From: Laura Gibbons <Laura.Gibbons@arun.gov.uk>
Sent: 18 May 2021 10:22
To: Planning.Responses <Planning.Responses@arun.gov.uk>
Cc: Simon Davis <Simon.Davis@arun.gov.uk>
Subject: RE: Planning Consultation on: AL/49/21/DOC

Application No: AL/49/21/DOC

Site Address: Springfield Hook Lane Aldingbourne PO20 3TE

Description of Works: Approval of details reserved by condition imposed under ref AL/64/20/PL relating to Condition Nos 5 - pre-commencement site meeting with Tree Officer, 6 - mitigation method statement, 7 - archaeology, 8 - Construction & Environmental Management Plan, 13 - detailed level survey, 14 - materials & finishes, 15 - details of all new screen walls & fences, 16 - landscaping, 18 - energy efficiency measures, 19 - covered & secure cycle parking spaces, 21 - broadband, 22 - charging of electric vehicles and 25 external lighting.

IMPERIAL HOMES LIMITED			
CLIENT		HOOK LANE ALDINGBOURNE	
TITLE	TJK1973	SHEET	SHEET 1 OF 1
JOB NO.		DATE	MAY 2021
CHECKED BY	S.K.	DRAWN BY	T.J.K.
LEVEL DATUM	Stn GPS on survey issued		
		SCALE	1:200

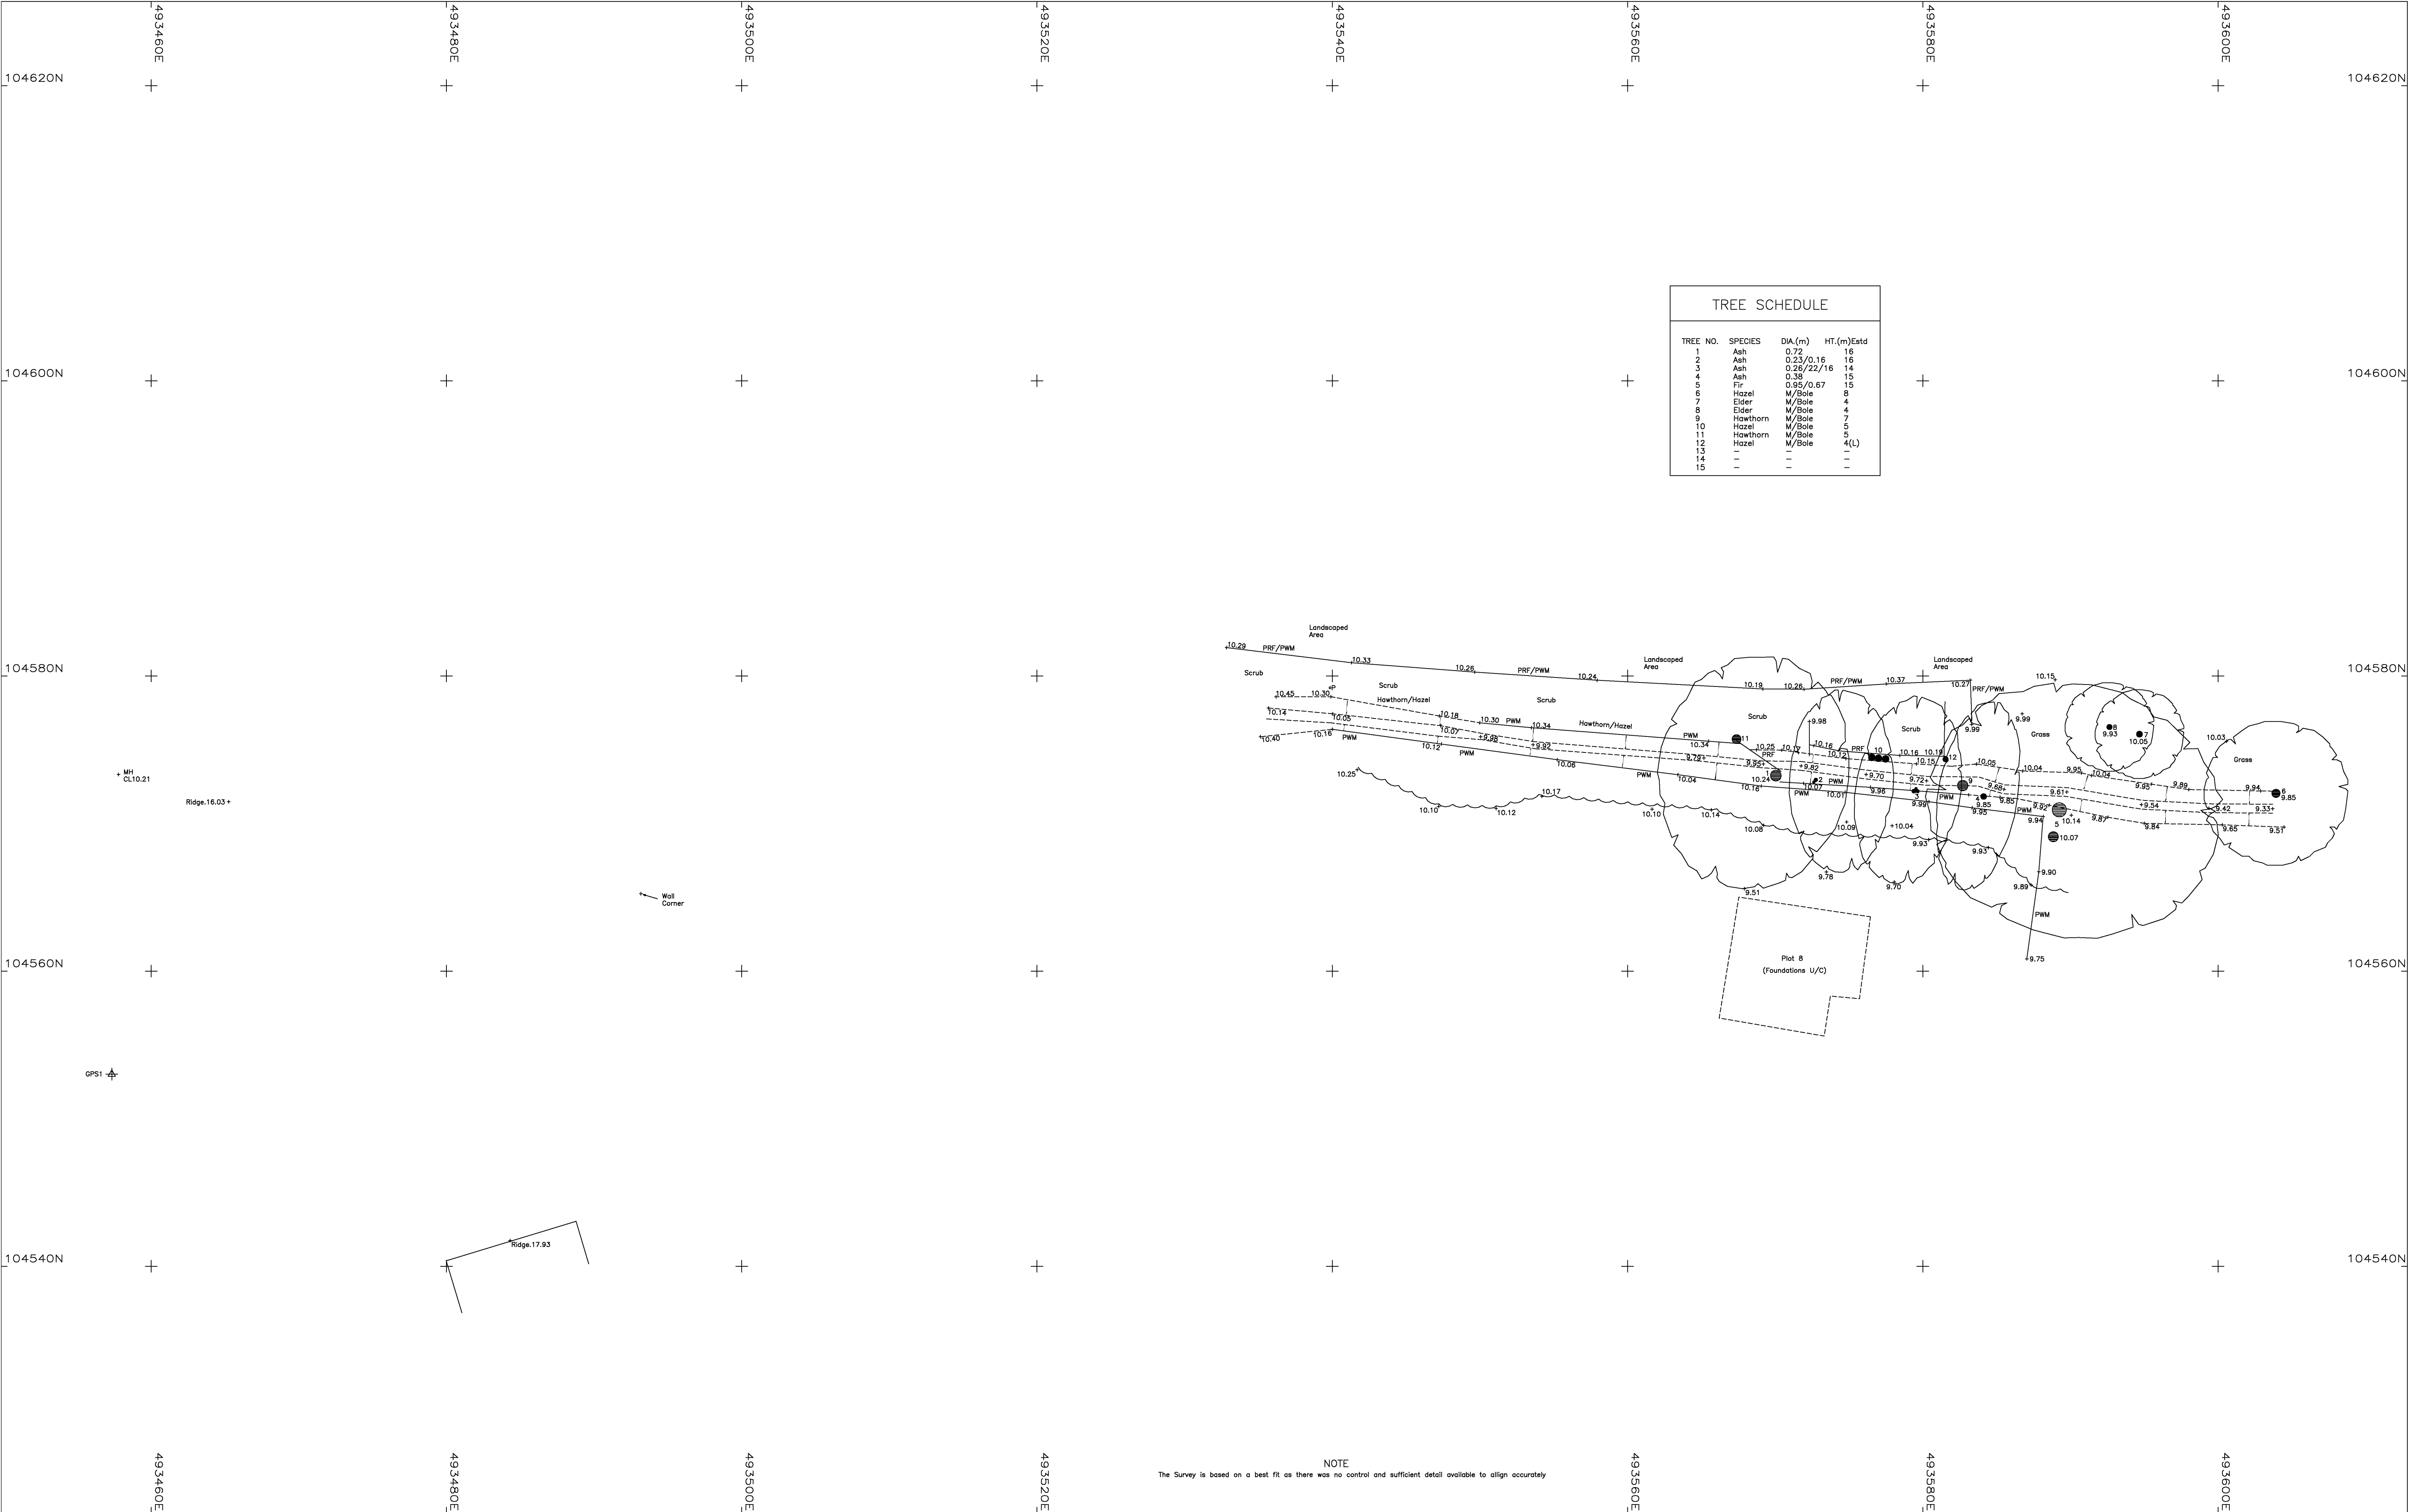
The levels plan supplied does not clearly define existing levels. Please can the applicant supply this so that it is clear what changes in level are proposed.

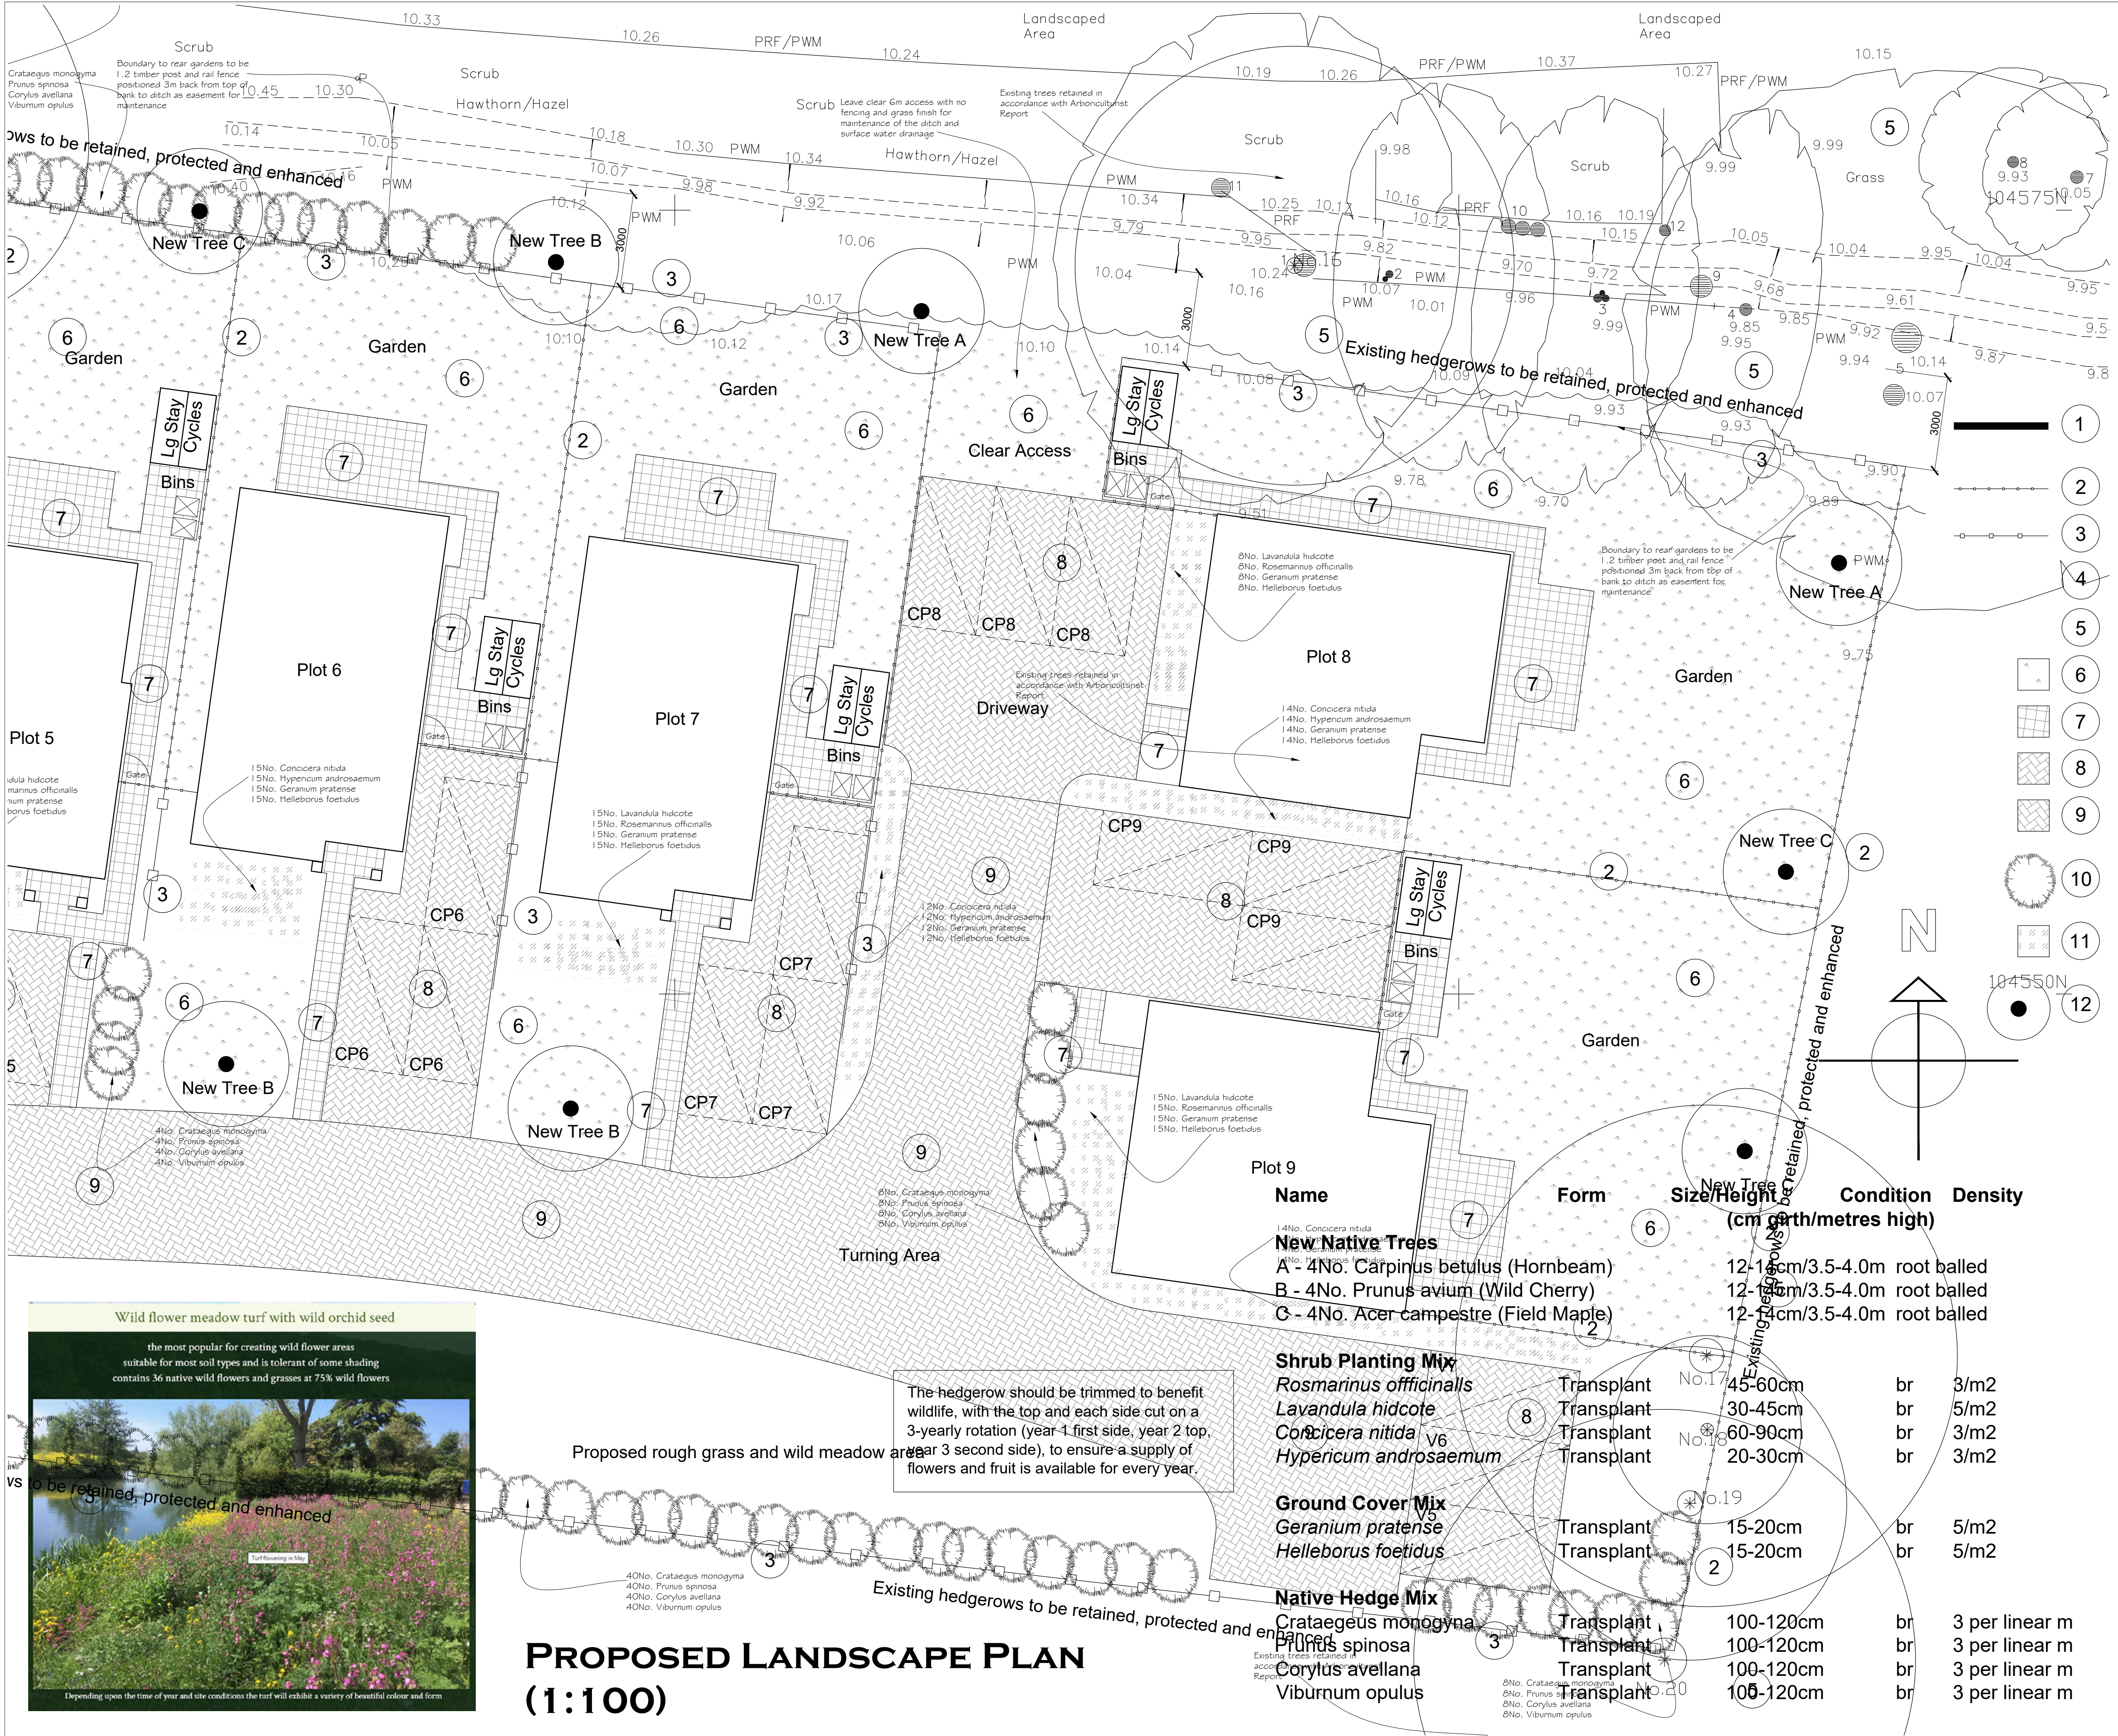
1.8m high timber close boarded fences are proposed in very close proximity to the northern watercourse. As per the requirements of our bye-laws, this condition, and our comments on the original application 3m easement to top of bank of the watercourse and demountable fences are required.

Without detailed drainage proposals being supplied it is not possible to review the landscaping strategy for conflict. If this condition is approved at this time it may have to be altered at later stages to ensure that conflict is resolved.
